**Teille Whiteman - Fwd: Modification application (SSD 4972), Sheraton Hotel Expansion, 161 Sussex Street Sydney**

I am writing to you in regard to the modification application, SSD4972 for the site located at 161 Sussex Street, Sydney (site). The site is located within the future CBD Rail Link corridor.

Figure 2: Approved structural columns, trusses and footings design under the tower (South Elevation)

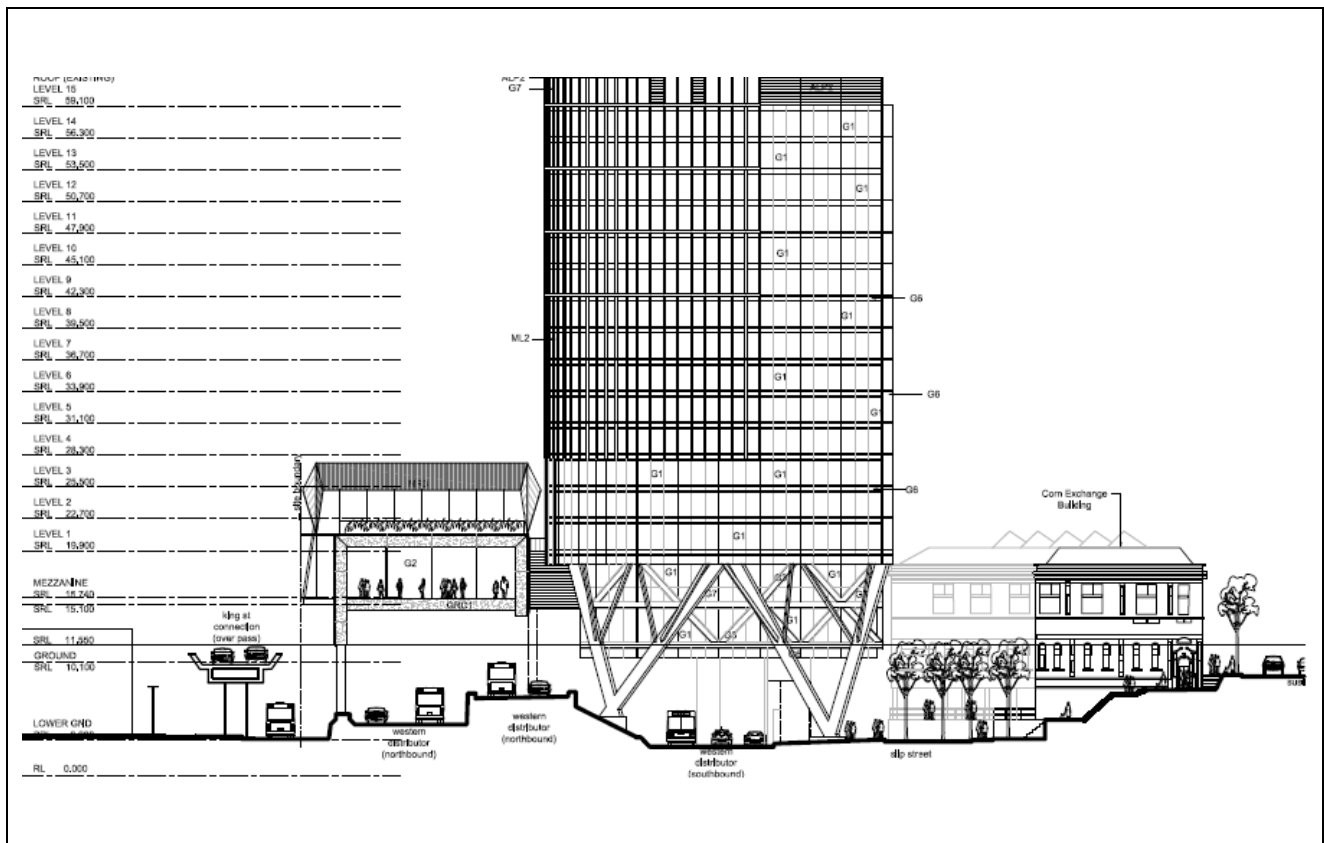
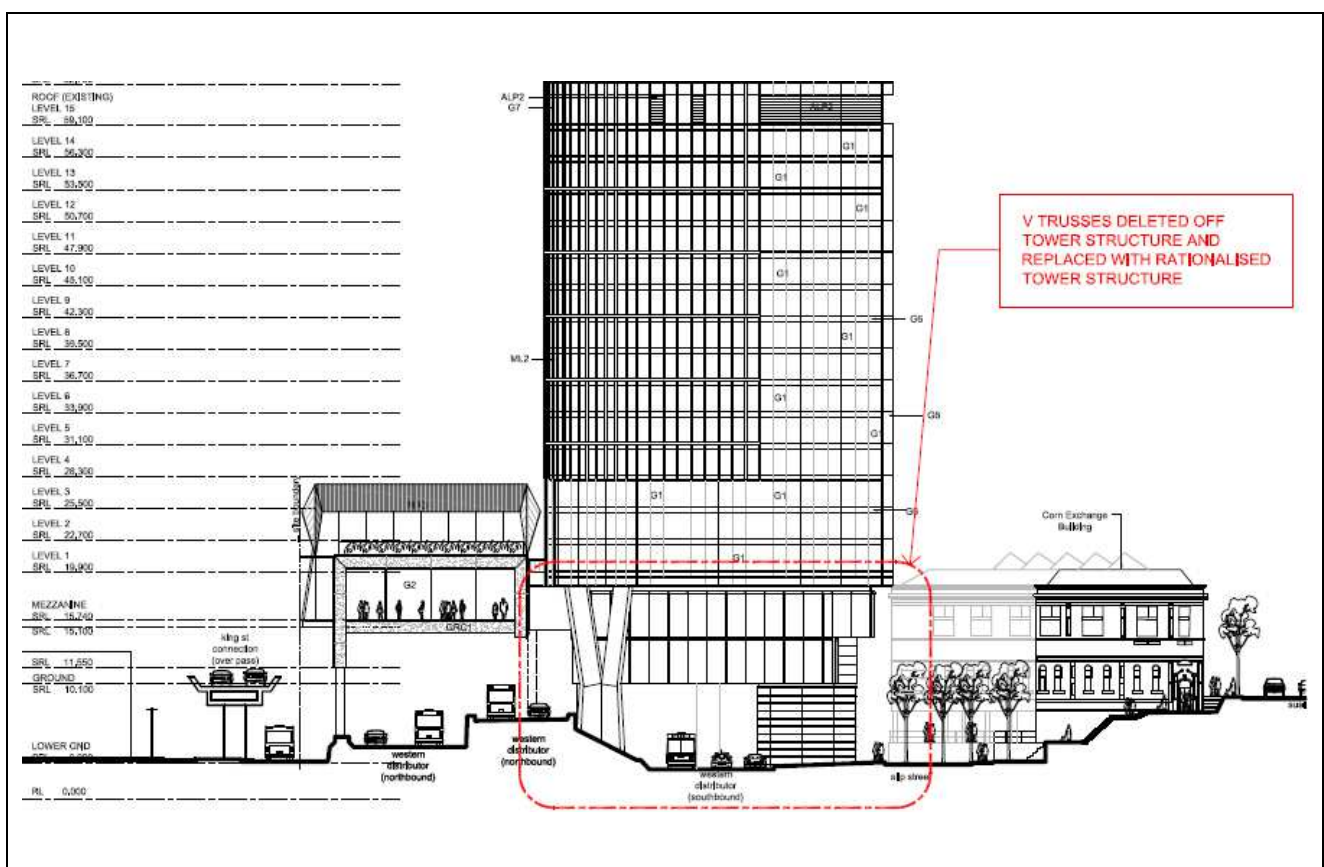
The application states that the the proposed amendments are a result of detailed design of the development. It also states that the proposal includes changes to the structural support system in parts of the development. As such, it is unclear whether these changes impact on the loading system and structural support system below ground. As such, Transport for NSW require additional information to properly assess the proposal. Given this, we request that the Department of Planning and Infrastructure (DP&I) place a 'stop the clock' on the assessment the application in order to seek additional information from the applicant on the proposed foundation system and also provide us with relevant design calculations for loading on the foundations.
